**WEST SUSSEX COUNTY COUNCIL
STRATEGIC PLANNING CONSULTATION**

SUBJECT: AL/75/14/OUT - Outline application with some matters reserved for a residential development to the west of the site comprising 2 no semi detached three bed houses and 1 no detached two bed bungalow with improved access off Hook Lane with all other matters reserved.

Woodgate Farm, Westergate Street, Aldingbourne, PO20 3SS

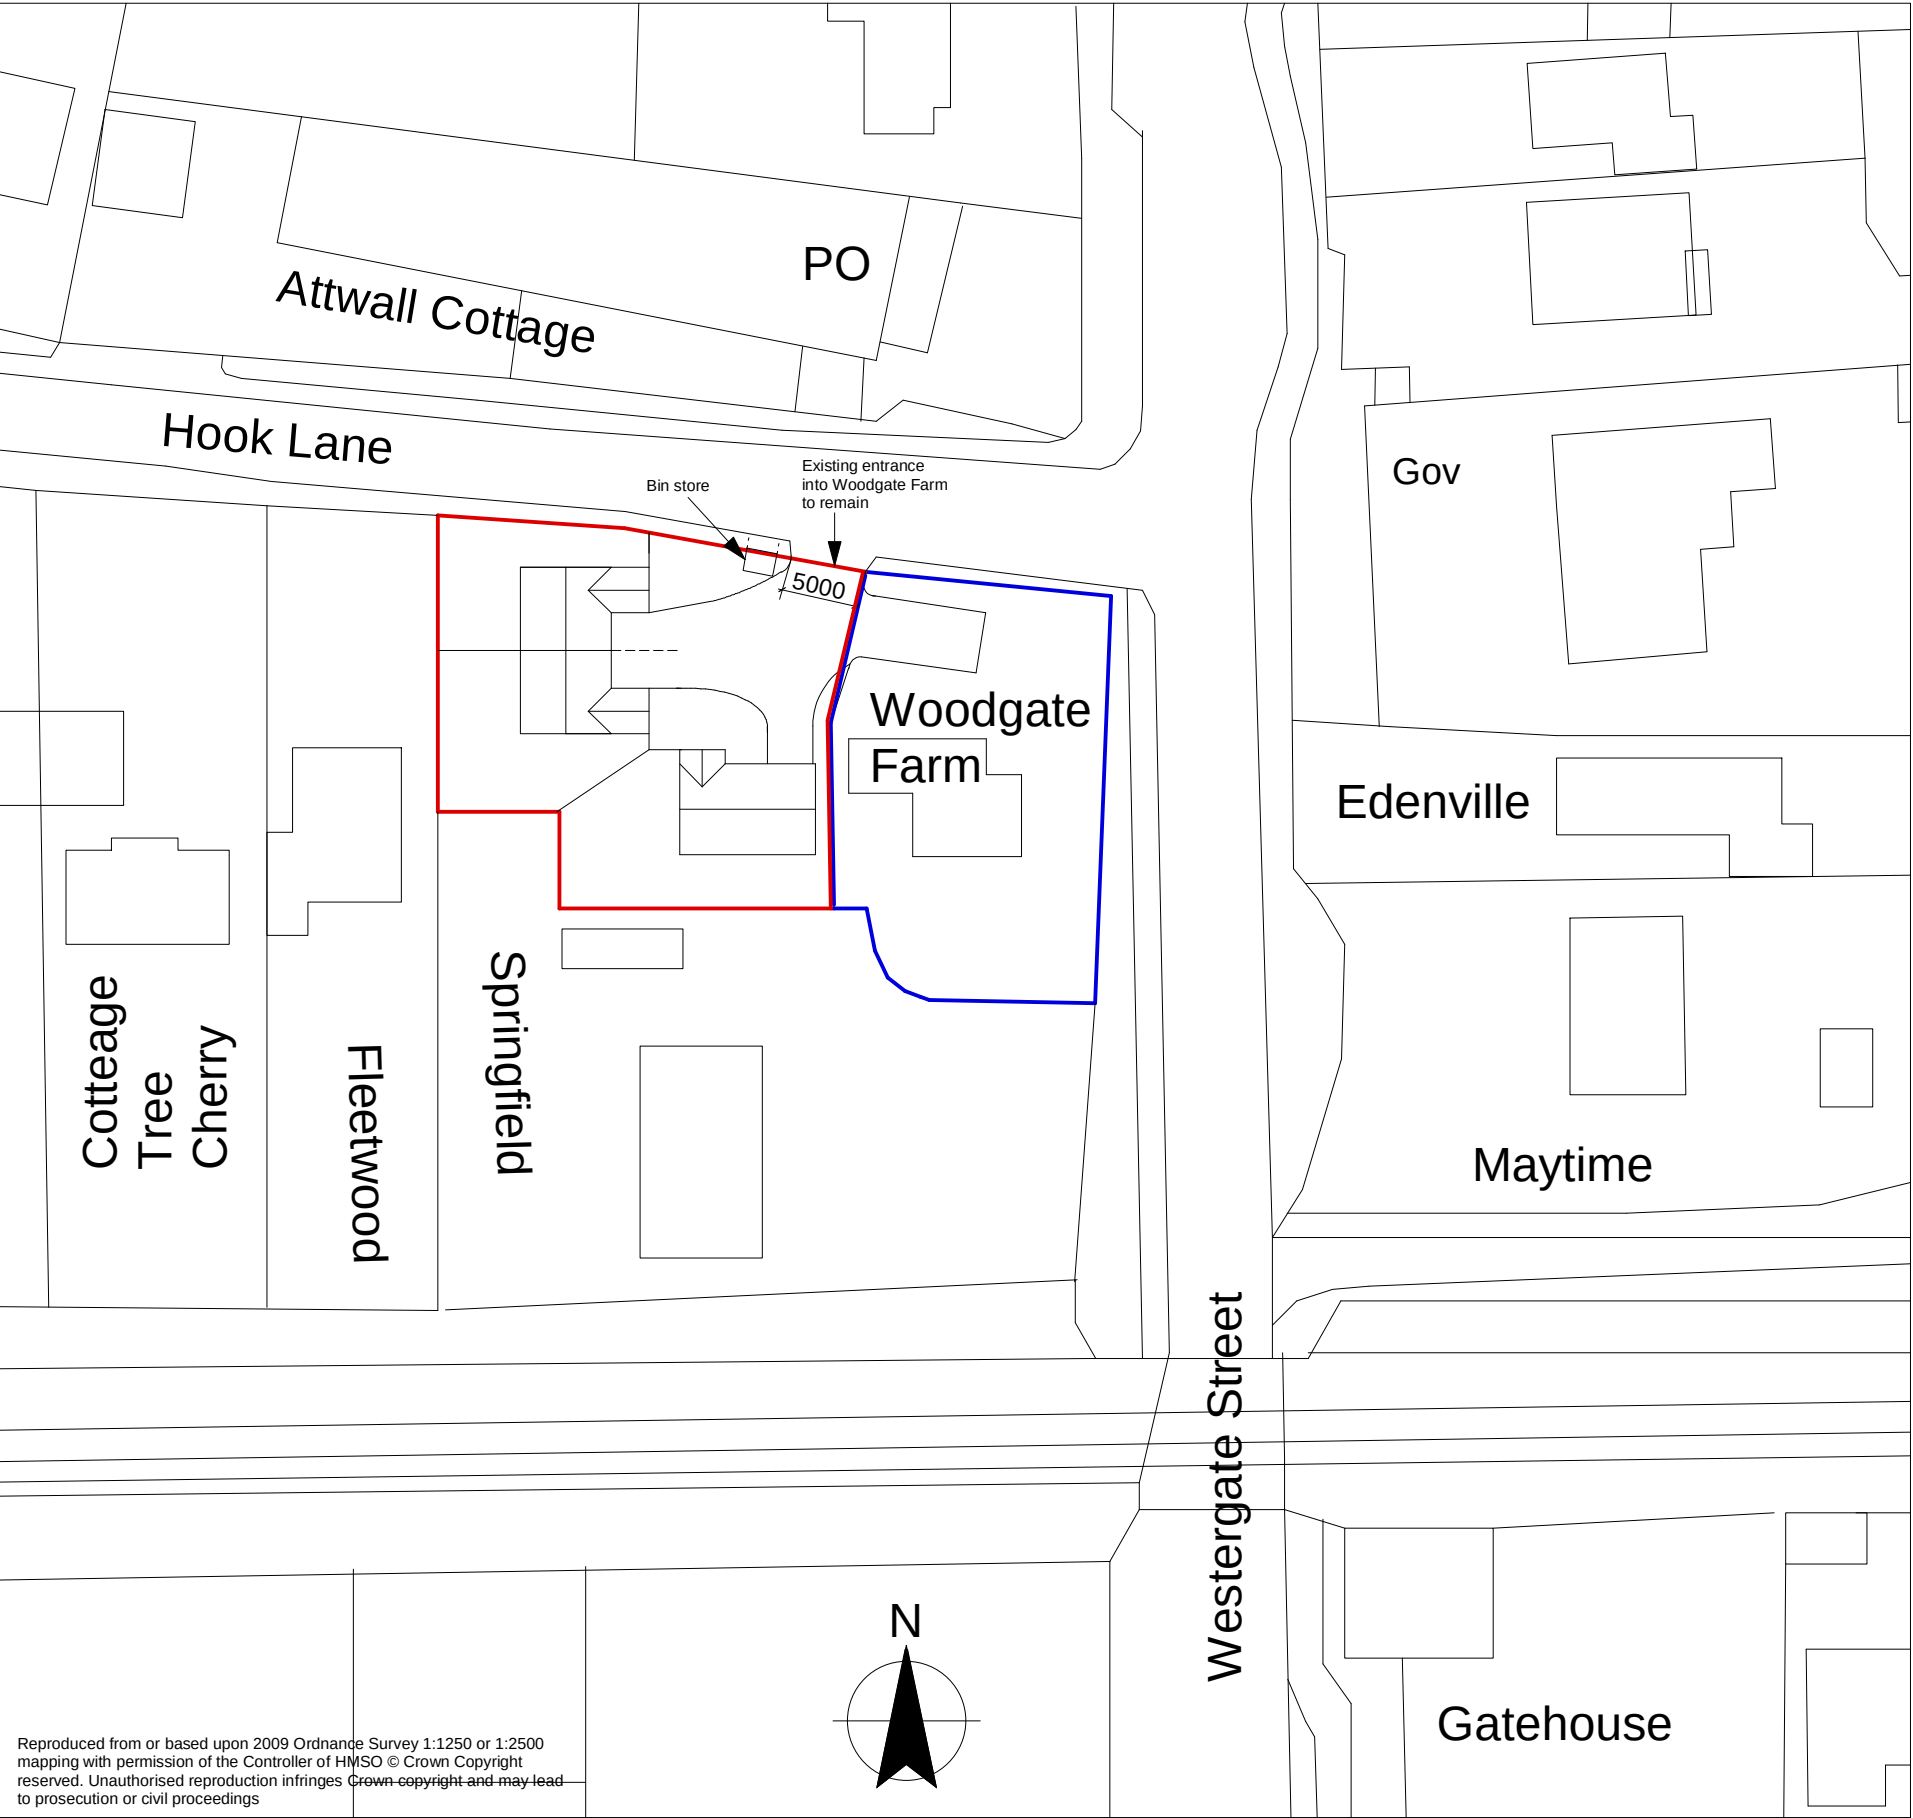
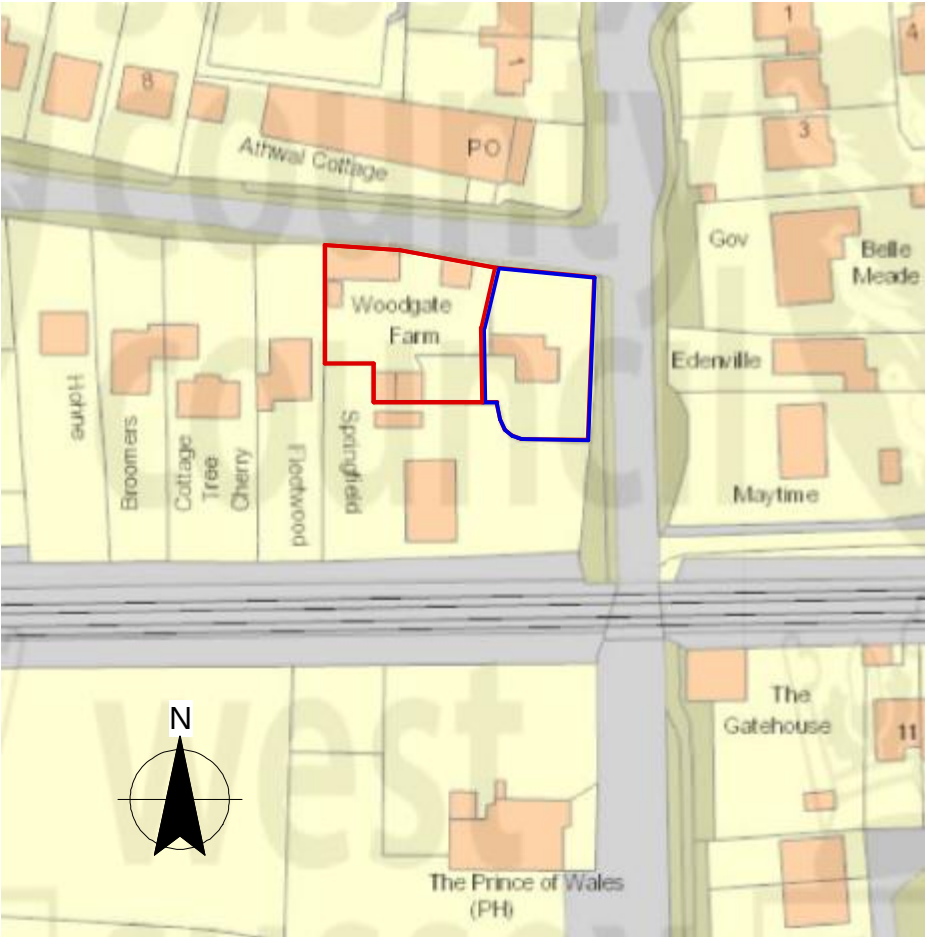
The site access point is located on the southern side of Hook Lane which is a 'C' classified road subject to a 30 mph speed limit at this point. There is a small strip of highway verge which separates the edge of Hook Lane carriageway and the boundary of the site though it should be noted that the boundary treatment to the property at present is in close proximity to the edge of carriageway. It appears that a degree of on street car parking takes place on the northern side of Hook Lane at this point; this is likely associated with the adjacent convenience store. The access point is located approximately 20 metres west of the junction where Hook Lane adjoins the A29 Westergate Street. While Hook Lane is subject to a posted 30 mph speed limit, actual road speeds may be lower than this to the presence of street car parking and the proximity to the junction of Hook and Westergate Street.

A net gain of three dwellings on this site would be considered to result in an intensification of use of the existing point of access. The existing point of access is to remain in the same location however be widened to 5.0 metres. This width is considered suitable to allow opposing vehicle to pass at slow speed. From inspection of the plans provided I do hold concerns that the level of available vehicle visibility provided at this point of access is substandard. This is due to the close proximity of the boundary walling to the carriageway edge. The design and access statement states that the access will be provided with visibility splays that accord with manual for streets. No such splays have been demonstrated on the plans provided. It would be advised that splays of 2.4 x 43 metres would be required. It is difficult to ascertain by eye an accurate reflection of actual road speeds and therefore a departure from the standards stated above would require the support of a speed survey to determine the 85th percentile road speeds in this location.

Whilst I appreciate the developments parking and turning provision would be considered under reserve matters I would provide the following advice at this stage. The site at present is provided with a turn on site facility. The applicant should ensure that the turn on site facility is not lost as a result of this proposal, even after the proposed parking layout is taken into consideration. Using the WSCC Car Parking demand calculator I would anticipate a development of this size in this location to attract the demand to park at least 9 vehicles. The plans provided do not demonstrate that a parking facility for 9 vehicles including a turn on site facility are, or could be, provided with any certainty.

In conclusion I would ask that the applicant demonstrate that an appropriate level of vehicular visibility can be achieved in accordance with the comments above. I'm also minded to ask for additional information demonstrating an appropriate level of vehicle parking and turning on the basis that the scale of the development is material in

determining an appropriate level of parking on site. Based on the plans provided I'm not convinced this can be achieved satisfactorily.

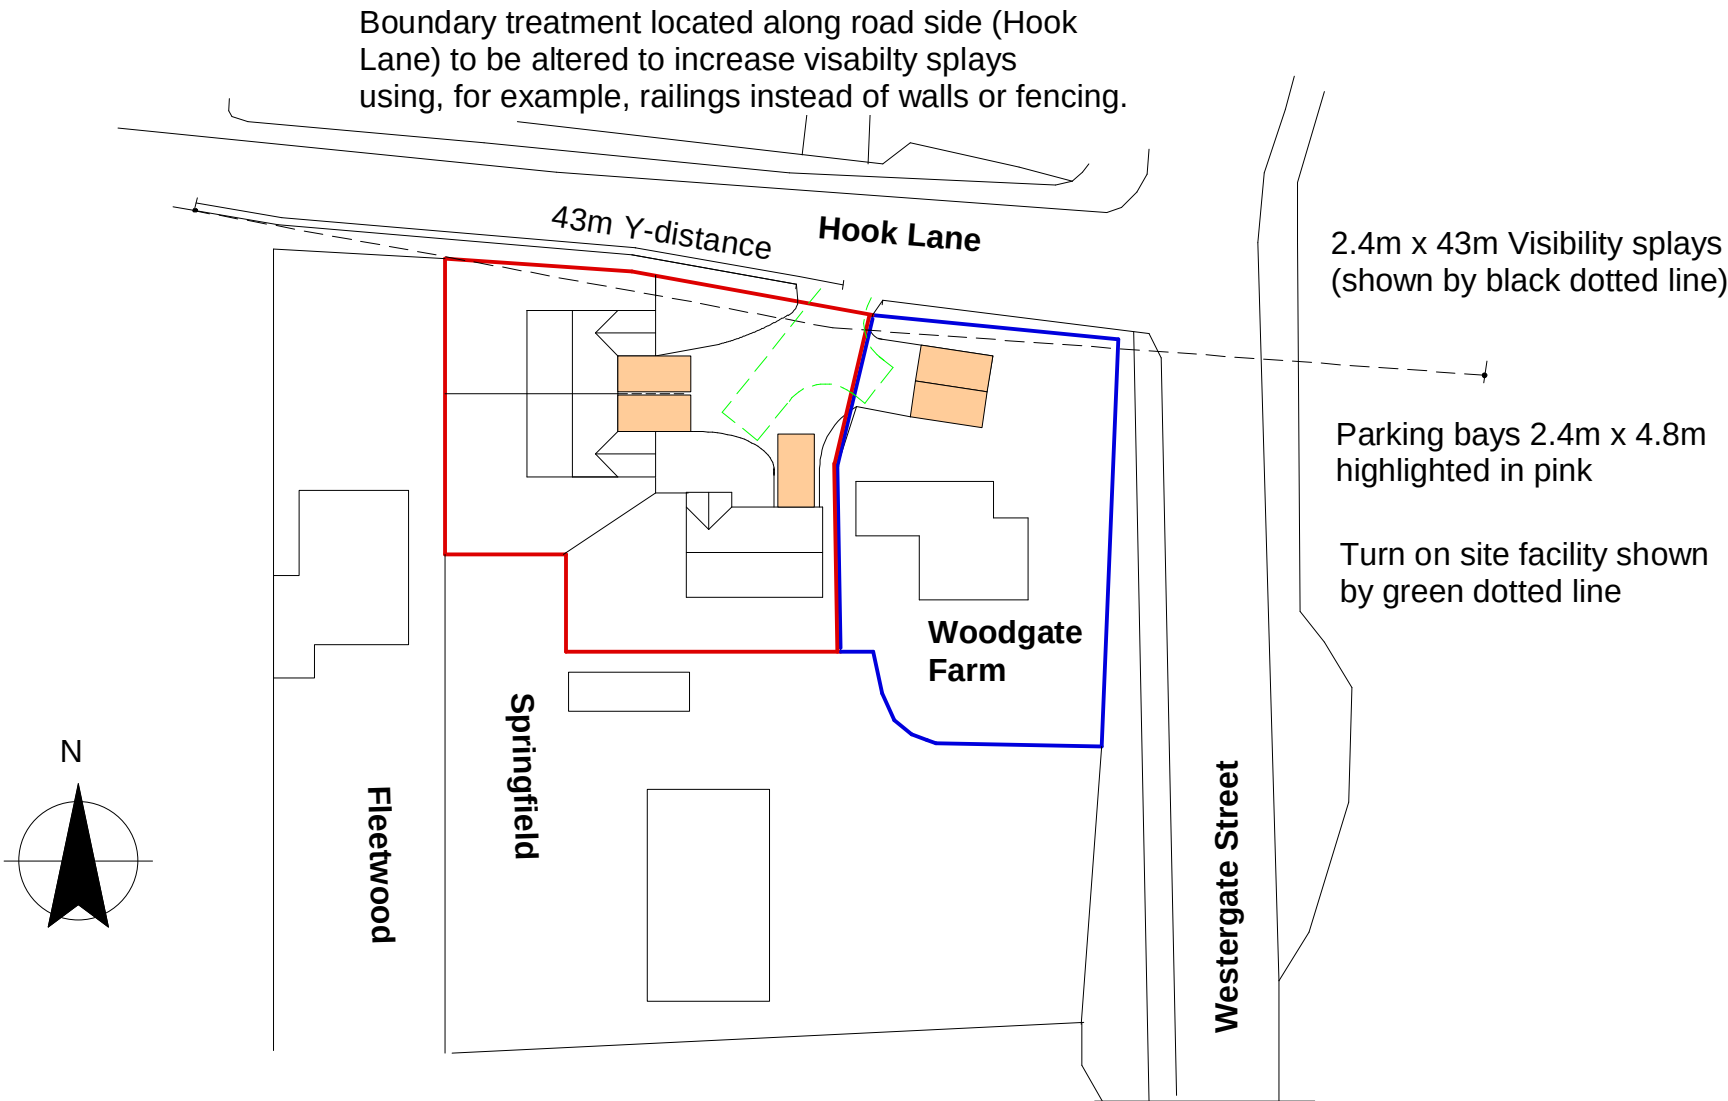
The applicant should also provide secure and covered cycle parking for at least 2 cycles per dwelling.
